**Park Farm House, Street Heading North From
Acre Ditch, Burdrop, OX15 5RN**

22/00687/F

Proposal: Opening up and widening of blocked up window to north elevation of north wing and blocking up of existing window to west elevation of north wing. Replacement of garage doors with glazed French doors. Replacement of uPVC windows with new uPVC windows. Installation of flue to log burning stove. Associated internal works.

| DRAWING NO. 21126(PL)205 | REVISION C |

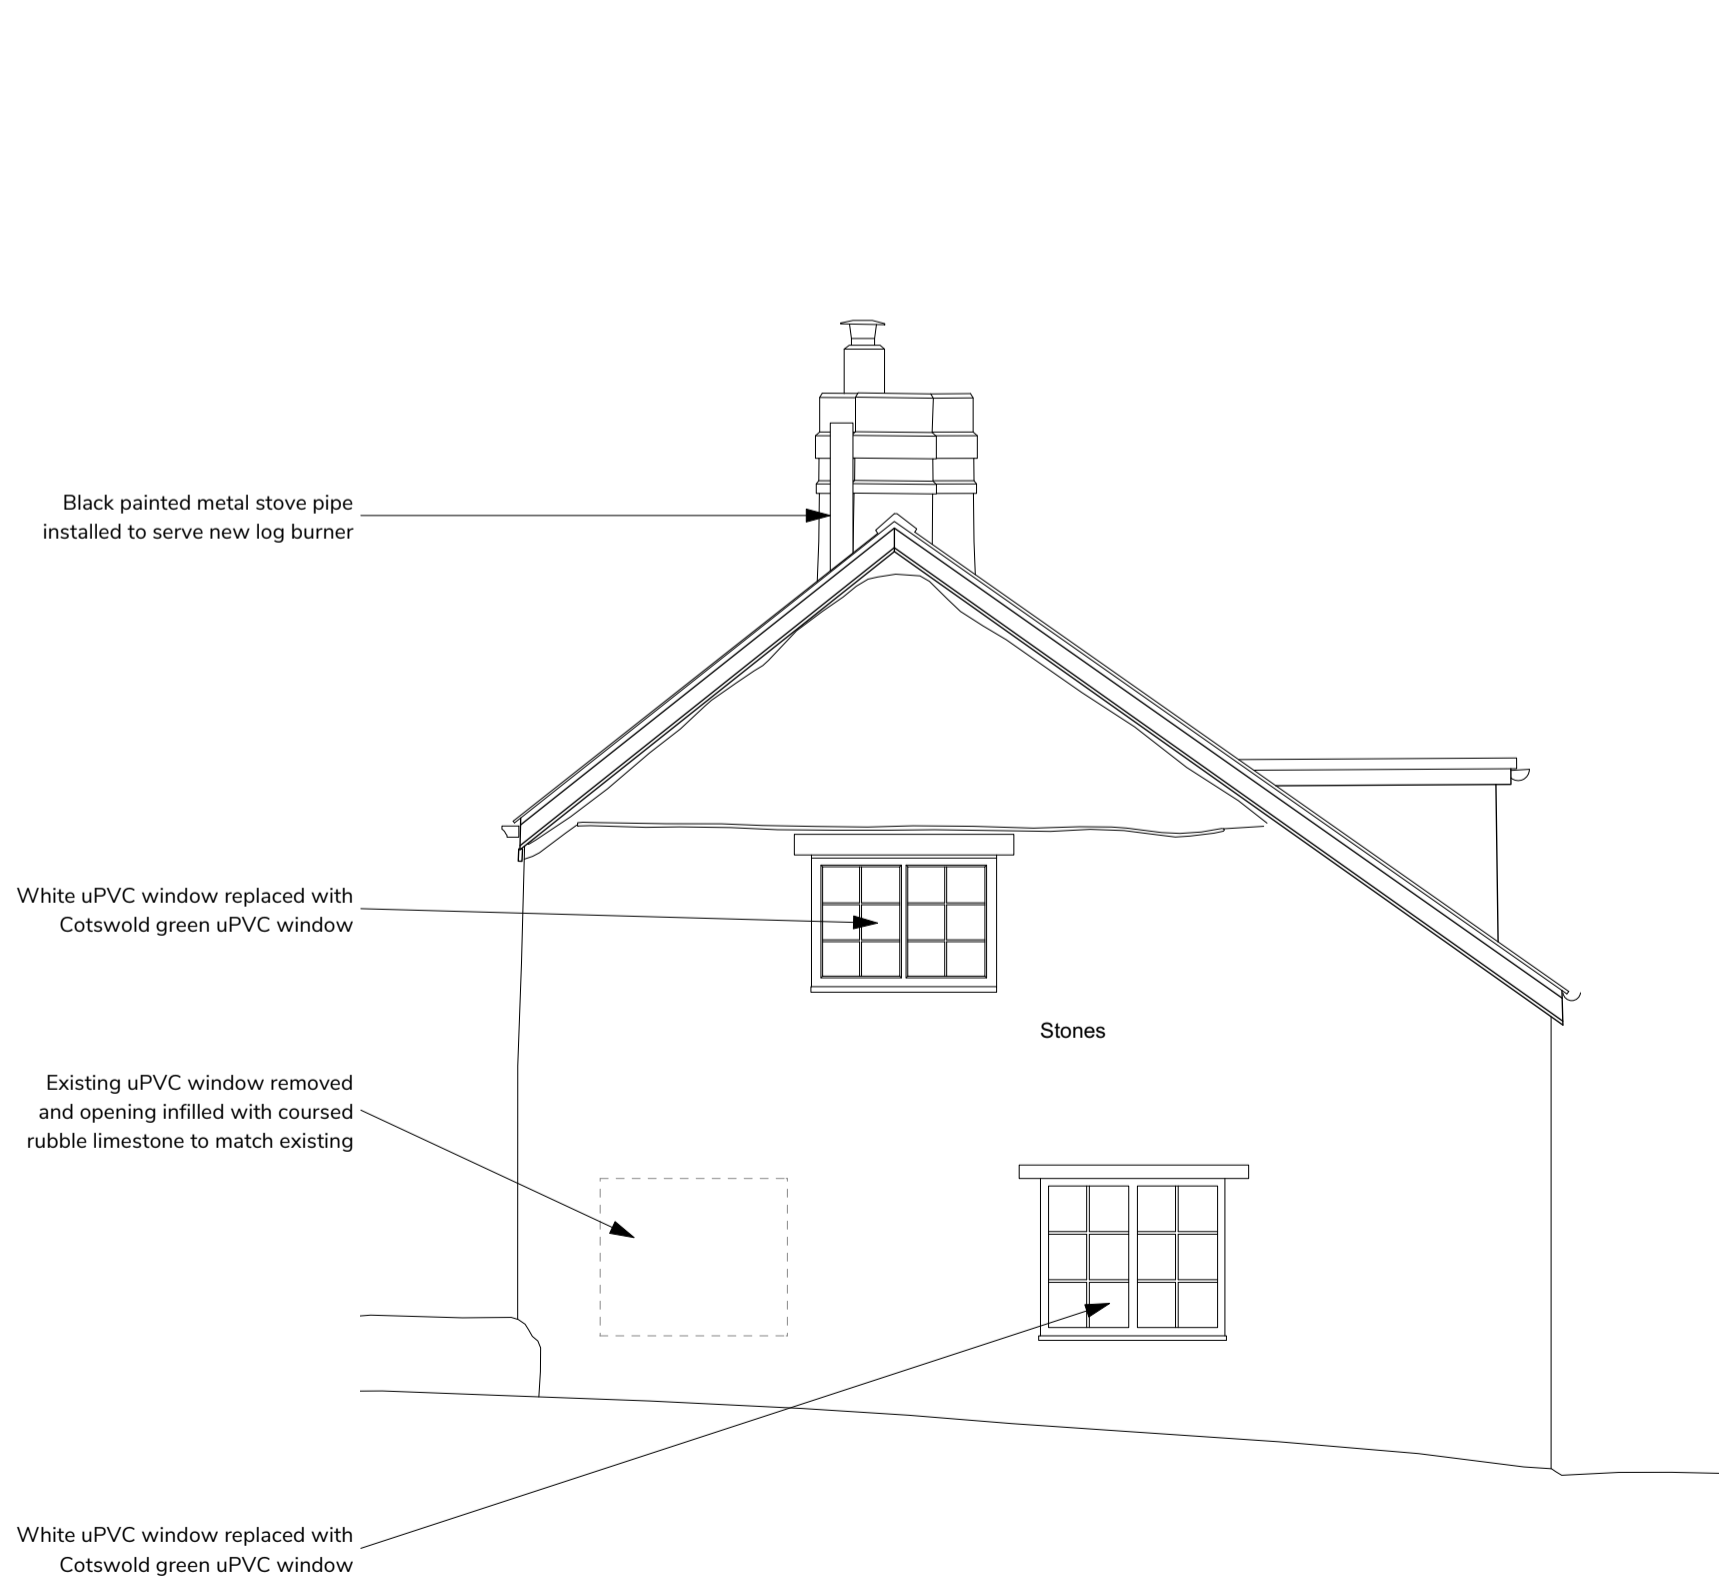
Scaling off the supplied drawings, the height of the proposed flue would measure 0.7m and thus not exceed the highest part of the roof by more than 1m.

The proposed opening up and widening of a blocked-up window to the north elevation of the north wing would be appropriate to the dwelling and restore a balance and visual cohesion to the elevation.

The blocking-up of an existing window to the west elevation of the north wing would create a visual imbalance. However, there is a tradition of windows being blocked and unblocked, particularly in farm buildings, as the history and use of the building evolves and changes over time and this change would therefore not necessarily be out of place and is considered acceptable.

Although the proposed use of uPVC is not in keeping with the overall character of the original building and its location within the wider conservation area, the proposed materials would match those of the existing dwelling

DRAWING NO. 21126(PL)201	REVISION C
------------------------------------	----------------------

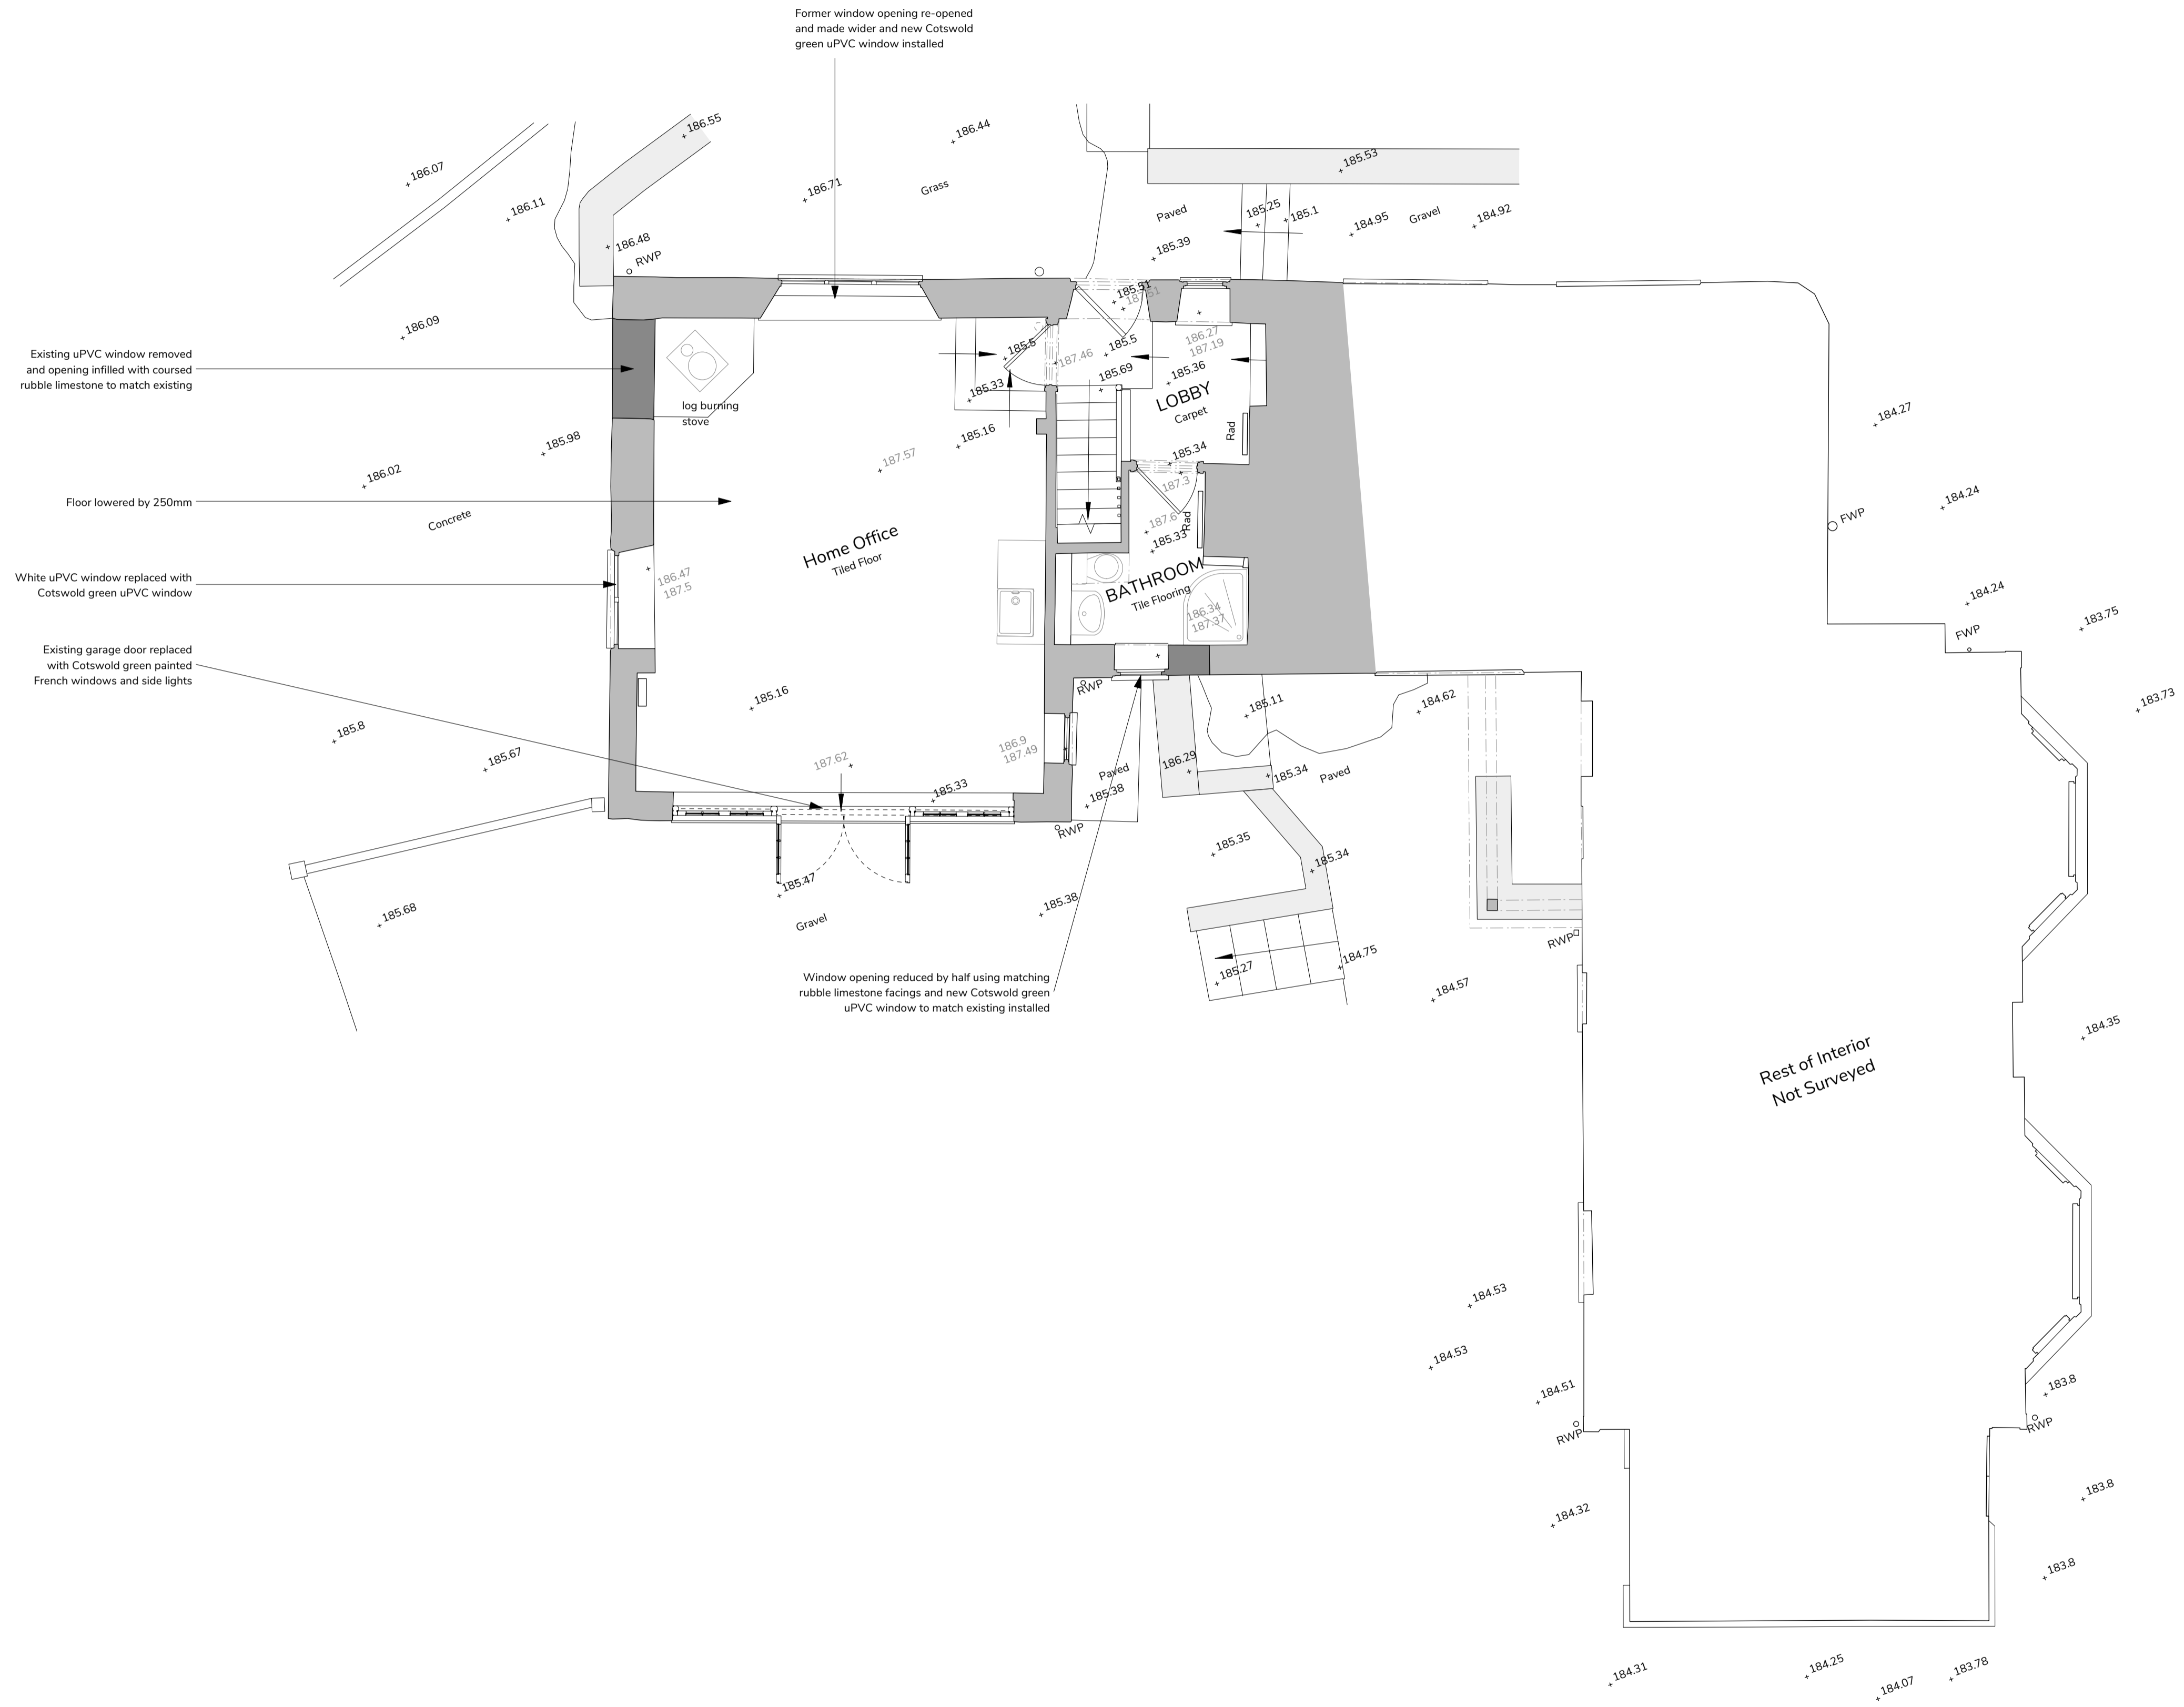
The conversion of the existing garage to living space would mean a reduction of parking spaces at the site. The proposed development also increases the number of bedrooms by one. However, on balance it is considered that there is an adequate area of hardstanding for off street parking to accommodate this.
